REQUEST

The petition proposes a unified development plan with common uniform zoning and development regulations for the development of a residential multi-family community on the entire 48.21 acre site which includes both the 36.67 acre Charlotte portion and the 11.54 acre Concord portion. The petition proposes up to 700 multi-family dwelling units.

STAFF RECOMMENDATION

EXISTING ZONING: R-22MF(CD) FOR CLT PORTION PER PET. #2021-020 AND C-2 FOR CONCORD PORTION

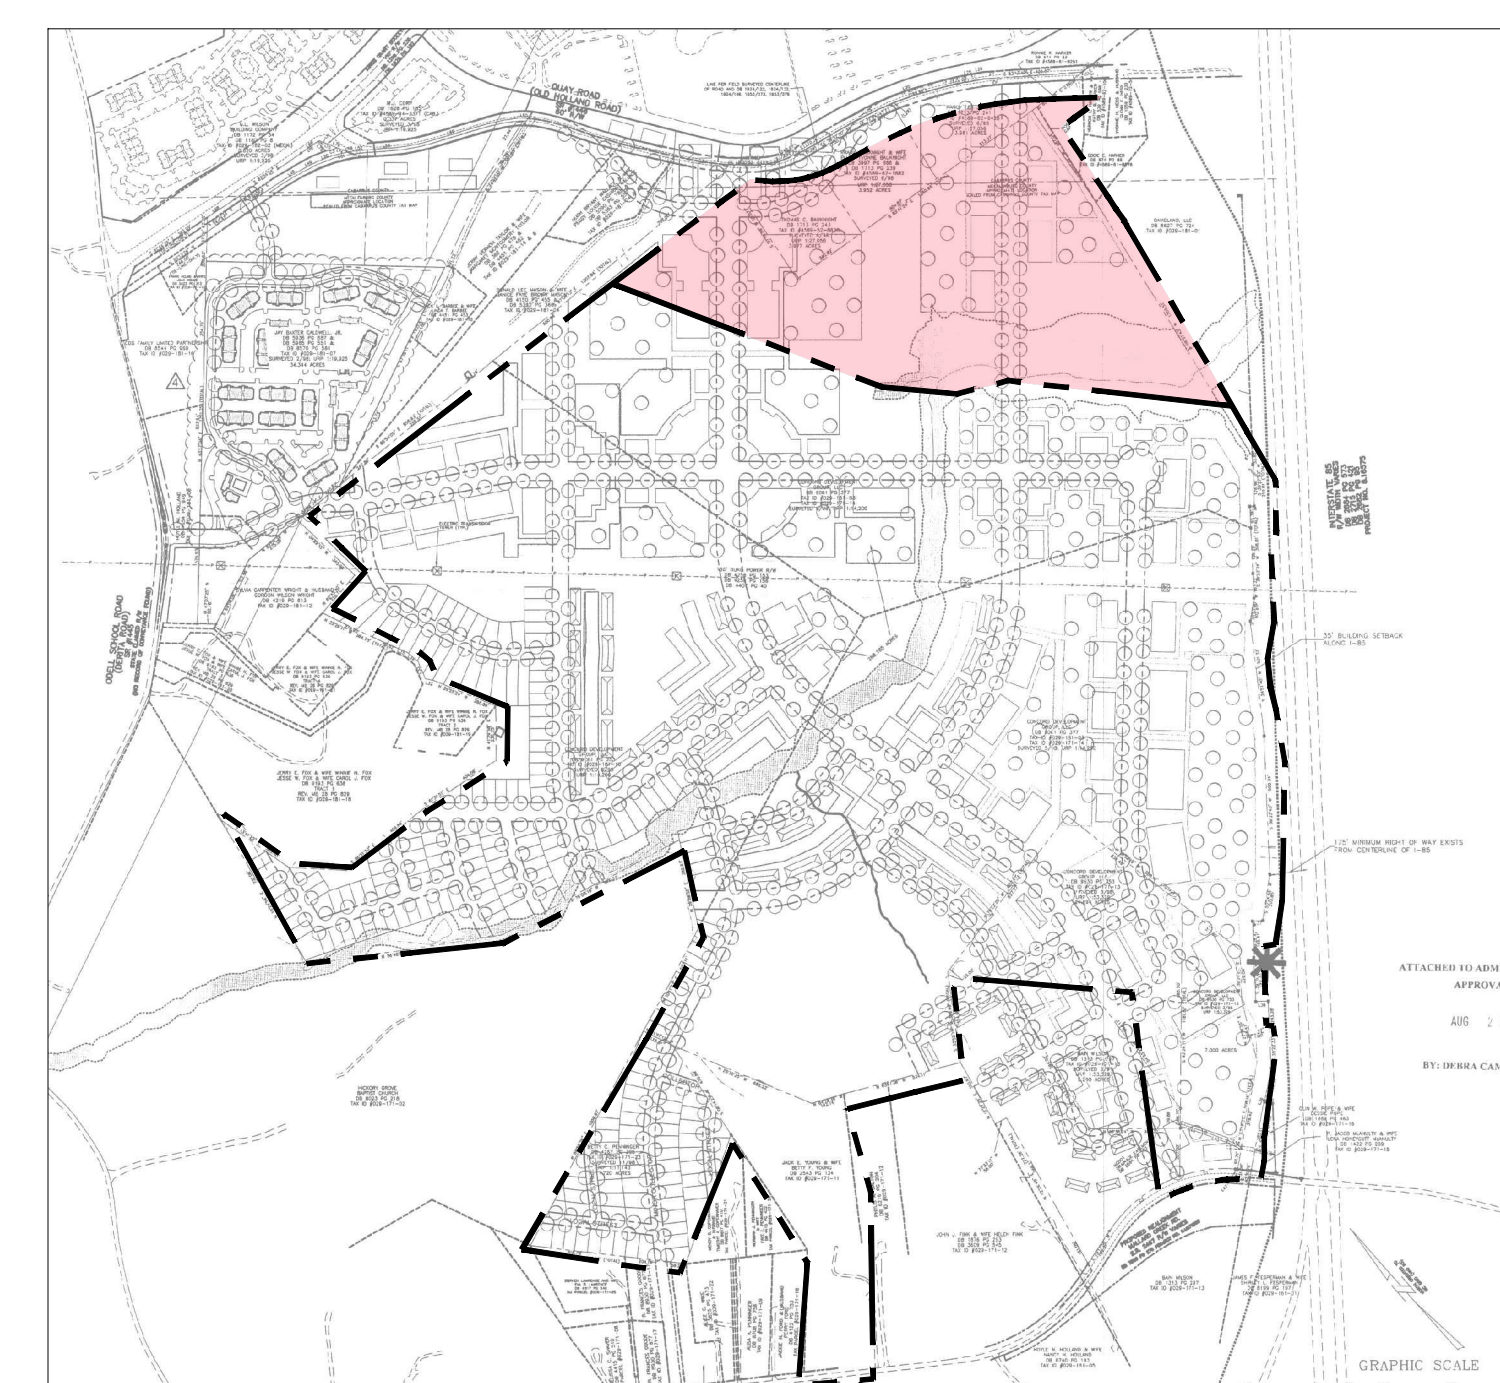
1. ~~Label and call out 8-foot planting strip and 8-foot sidewalk on roads on site plan.~~ Addressed
2. ~~Based on latest conversation with Land Development Subdivision, please label Road B as publicly maintained within Mecklenburg county on site plan and alter conditional notes in sections 3, 4, and 5 to reflect changes.~~ Addressed
3. Revise site plan and conditional notes(s) to commit to coordinating with CATS to provide a public connection to the nearest CATS bus stop to the North of the site.

4. ~~Minimum open space for R-22MF is 40%. Update plan.~~ Addressed
5. ~~In section 1e. the number of principle buildings (24 or 27) don't match.~~ Addressed
6. ~~Setbacks will apply to all internal required streets.~~ Addressed
7. ~~Make Road B public.~~ Addressed
